# CITY OF ALBUQUERQUE

March 26, 2020

**Re: TownHomes for Azar**  
**321 Sandia Rd NW**  
**Traffic Circulation Layout**  
Architect's Stamp 03-07-2020 (F14-D077)

TRAFFIC CIRCULATION PLAN

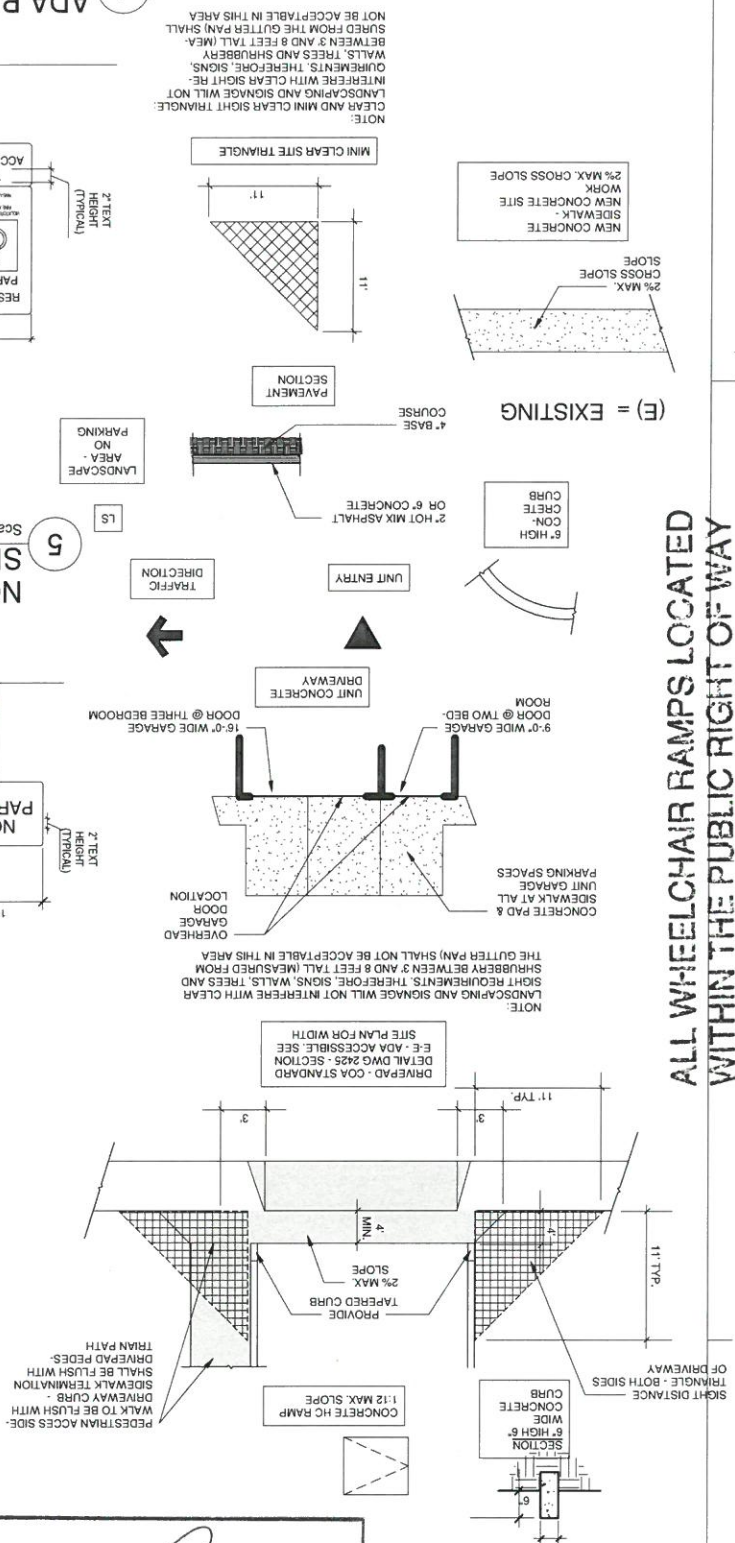
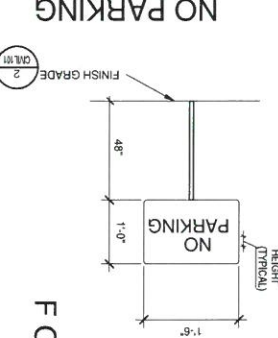
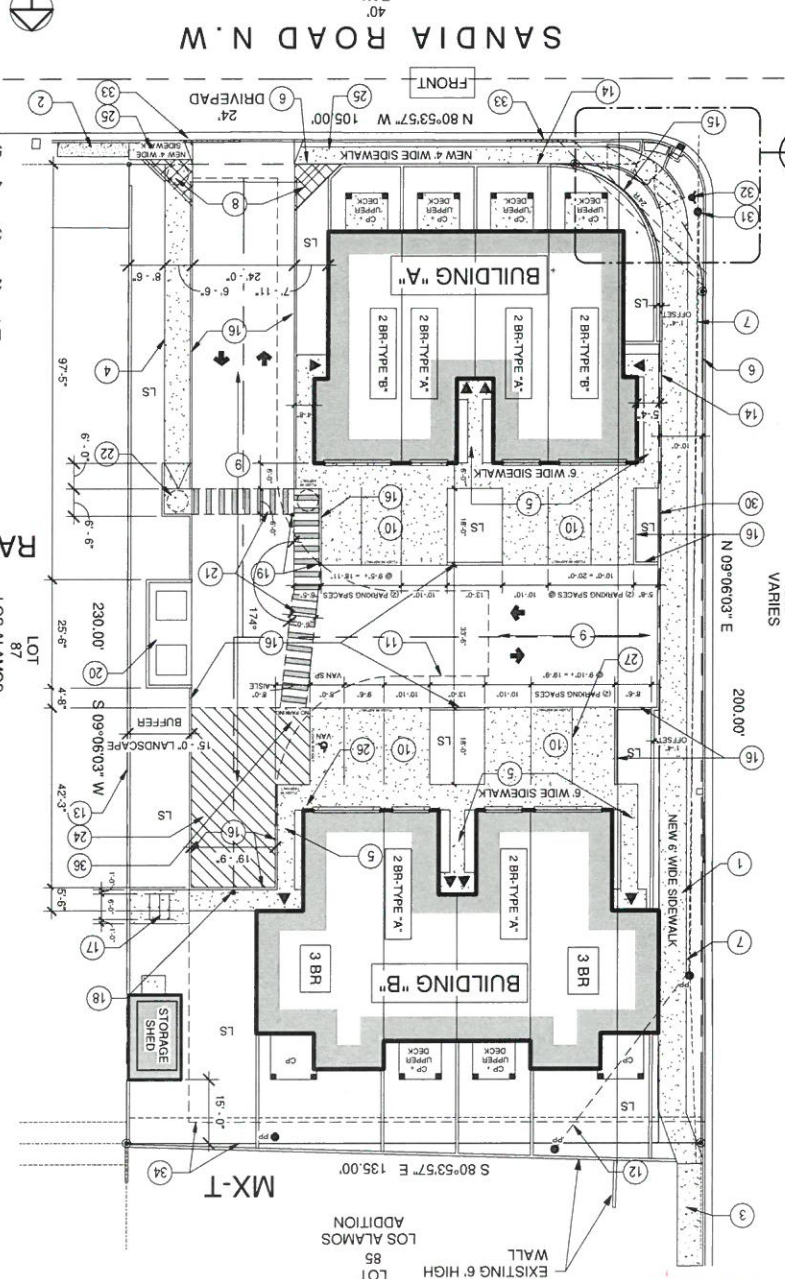
1. Please coordinate all calculations for parking spaces, including bicycle, and motorcycle parking with Zoning.
2. List the number of parking spaces required by the zoning code as well as the proposed number of parking spaces including bicycle and motorcycle parking.

3. Please identify all existing buildings, doors, structures, sidewalks, curbs, drive pads, wall and anything that influences the parking and circulation on the site.

4. Identify all existing access easements and rights of way width dimensions.
5. Identify the right of way width, medians, curb cuts, and street widths on 4<sup>th</sup> Street and Sandia Road.

6. Grades and slopes in the parking area and/or the ADA accessible parking areas appear to be too large. Please provide more detail.
7. Please list the width and length for all existing and proposed parking spaces. Some dimensions are not shown.

9. The ADA access aisles shall have the words **"NO PARKING"** in capital letters, each of which shall be at least one foot high and at least two inches wide, placed at the rear of the parking space so as to be close to where an adjacent vehicle's rear tire would be placed. (66-1-4.1.B NMSA 1978) and **painted blue not red.**

10. Please move the ADA curb ramp to the other side of drop inlet proposed on the corner of 4<sup>th</sup> Street and Sandia Road.
11. Are there any motorcycle parking required? If so then :Motorcycle parking spaces shall be designated by its own conspicuously posted upright sign, either free-standing or wall mounted per the zoning code.

16. Per the IDO, a 6 ft. wide ADA accessible pedestrian pathway is required from the public sidewalk to the building entrances. It appears the pathway encroaches into the proposed driveway transition/wing which in turn reduces the 6 ft width. Is the path raised with curbing? Please label if curbing is being proposed on this path in any where else that has the line type.

17. All new sidewalks along streets should be labeled. Not all of the proposed sidewalk is labeled.
18. Curbing should be installed to delineate landscape, parking, and pedestrian ways and identify points of access. Please call out detail and location of barrier curb.

19. Parking areas shall have barriers to prevent vehicles from extending over public sidewalk, public right-of-way, or abutting lots.
20. The concrete surface is being proposed has no detail that specifies the thickness (key note 16).

21. Please specify the City Standard Drawing Number when applicable.

- 22. Key Notes 5 needs to have 4 ft. wide sidewalk.
- 23. Key Note 17 reference the number of spaces proposed for bike parking but it is not included in Parking Calculations.
